Ribble Valley Borough Council
Planning Section
Council Offices
Church Walk
Clitheroe
BB7 2RA

Planning Application No: 3/2025/0223
Grid Ref: 374321 442337
Proposal: Proposed two-storey extension to side.
Location: 21 Park Avenue Clitheroe BB7 2HP

PROPOSED GROUND FLOOR PLAN
SCALE 1:50

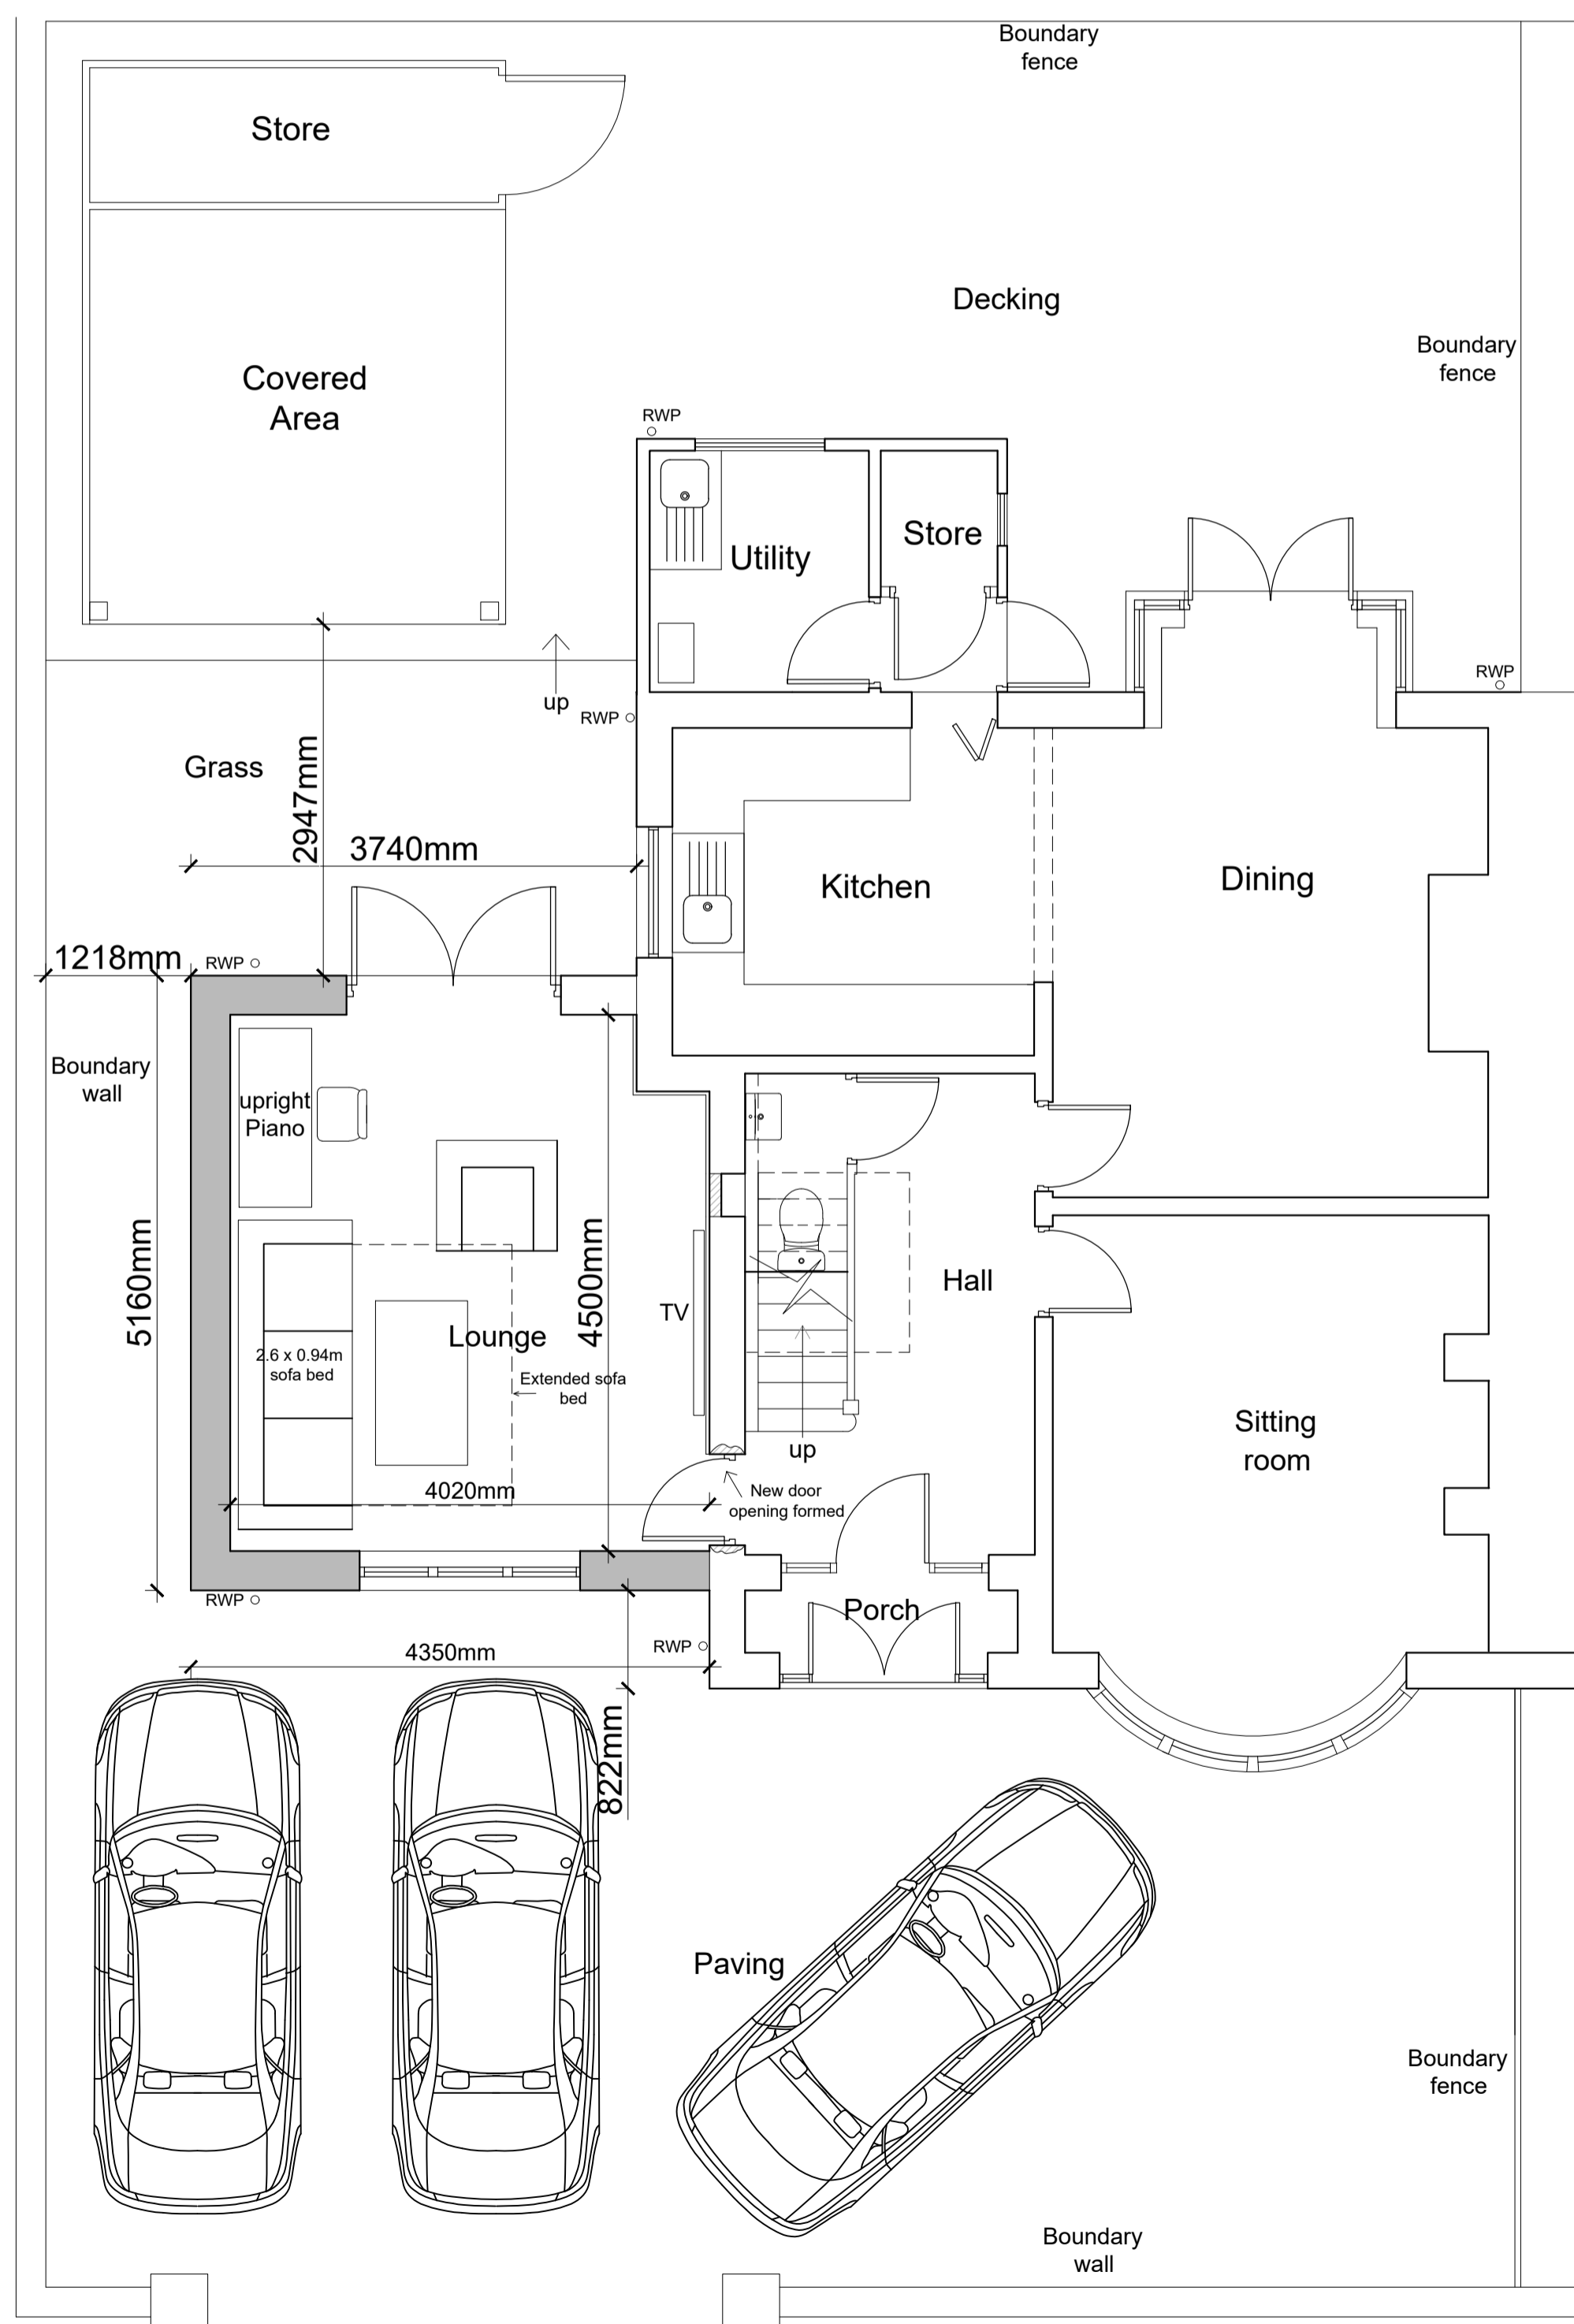
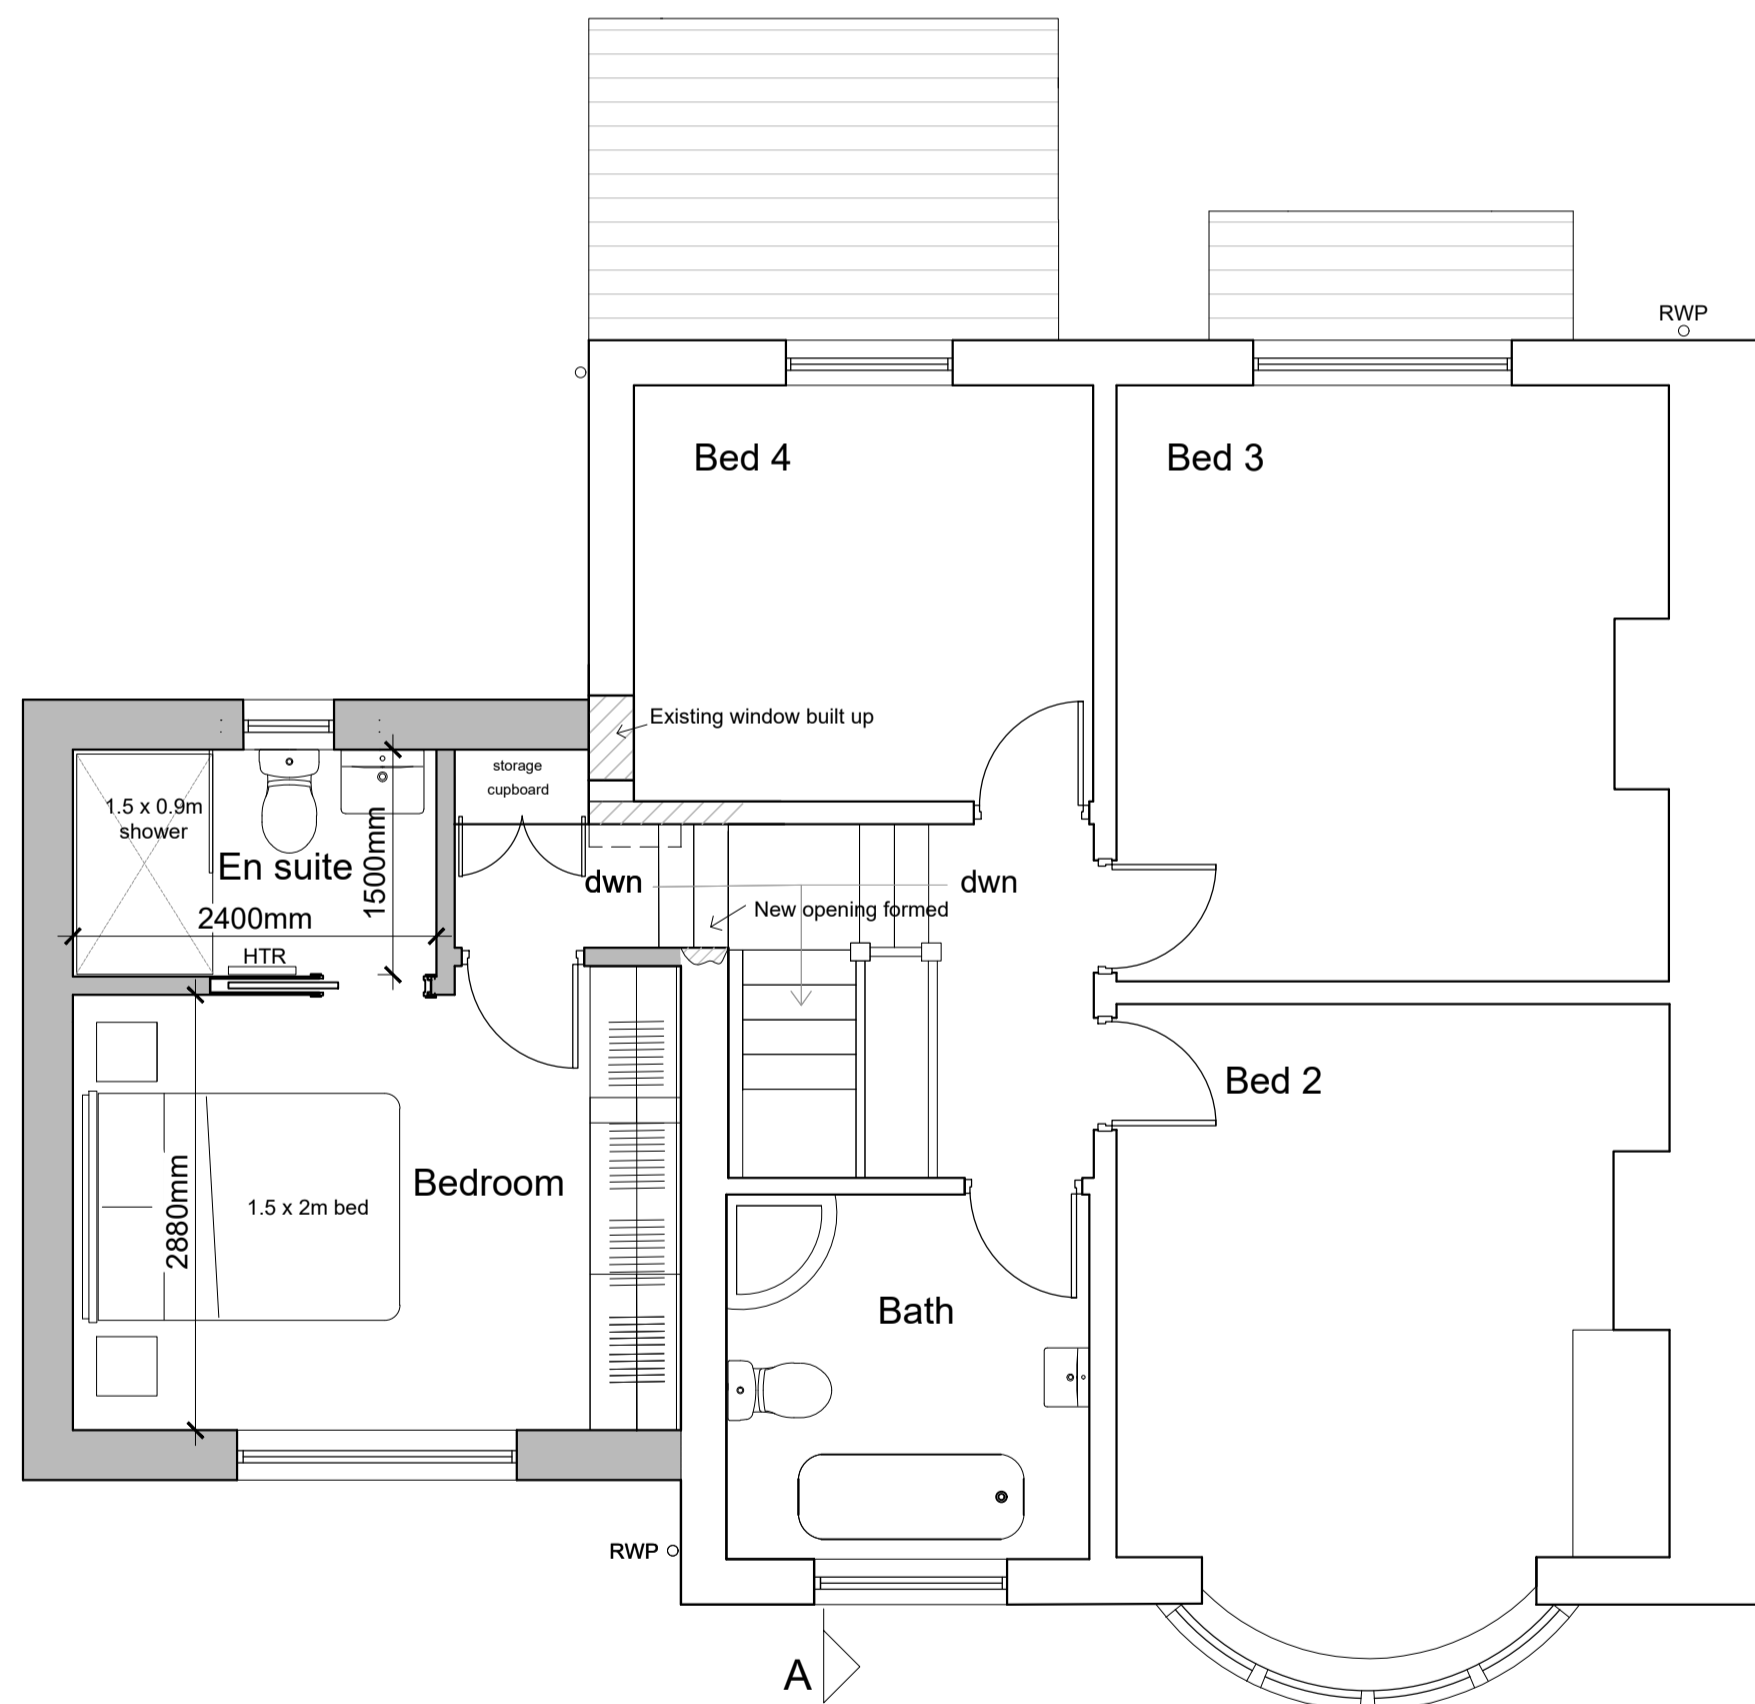
Further to the 2 new pieces of information regarding this proposal, an amended plan is required to show the 3 parking spaces being provided are useable, therefore, preference is for them to be side by side. The property is located on a Cul-de-Sac, and at the time of my visit, parking on the road was full to capacity.

The driveway extension should be laid in a bound, porous material and the vehicle crossing will need extending to cover the full width of the parking area proposed for the 3 parking spaces, in order to prevent damage to the footway.

- The parking areas must be constructed in a bound porous material and created before first occupation up until the lifetime of the dwelling existing in its proposed state. Reason: To ensure that satisfactory parking is provided before the dwelling hereby permitted becomes operative.
